Subject: BN/49/18/PL - Amended house types at Ashdown Vale (former Pollards Nursery site), Lake Lane, Barnham

Have any of the conditions imposed on BN/19/16/PL (the 7 house' scheme) been discharged?

Worcester +
Floor Plans

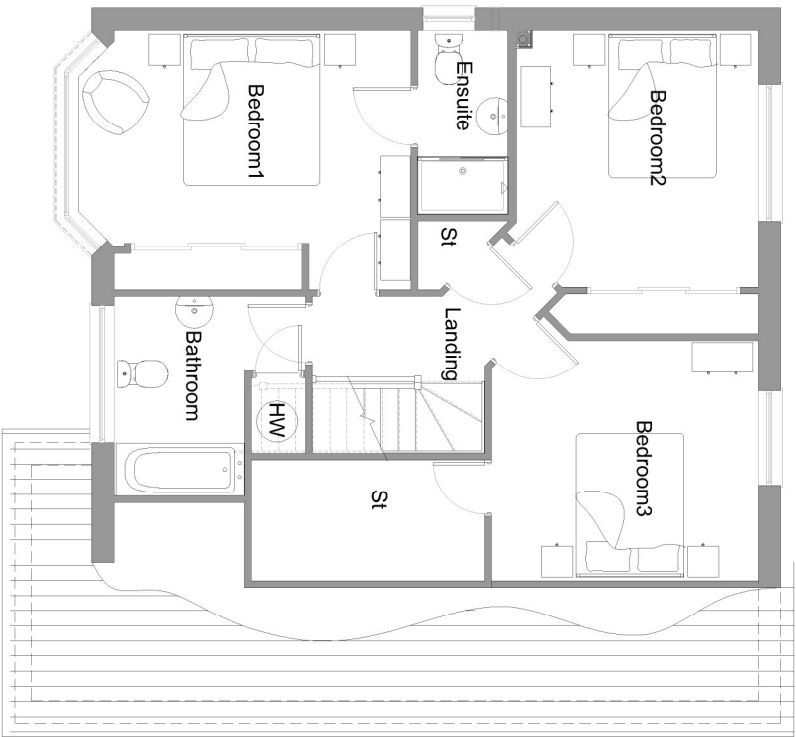
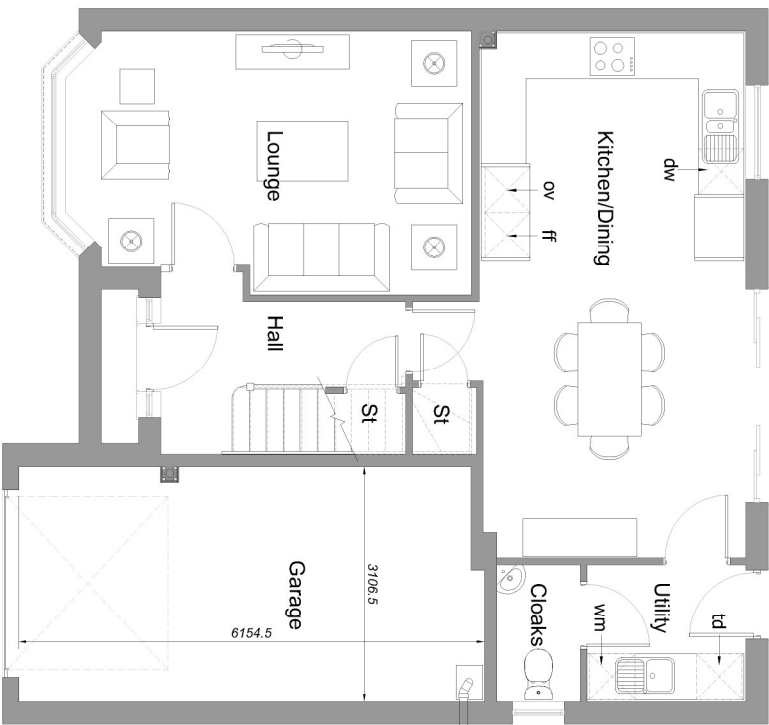
In application BN19/16/PL the Worcester house is described as a four bedroom detached house (Plot 4), but it is described in BN/49/18/PL as a 3 bed house. Why is there a discrepancy?

Please could you submit the elevation plans and the floor plans of the "Worcester" house type which is being replaced on Plot 4.

We have not discharged the planning conditions on the original permission. Once the decision has been issued on the S73 we will be looking to submit the details asap. In terms of the Worcester HT, the approved plans are attached and this shows a 3 bed house and this is how it is described on the approved site layout plan too.
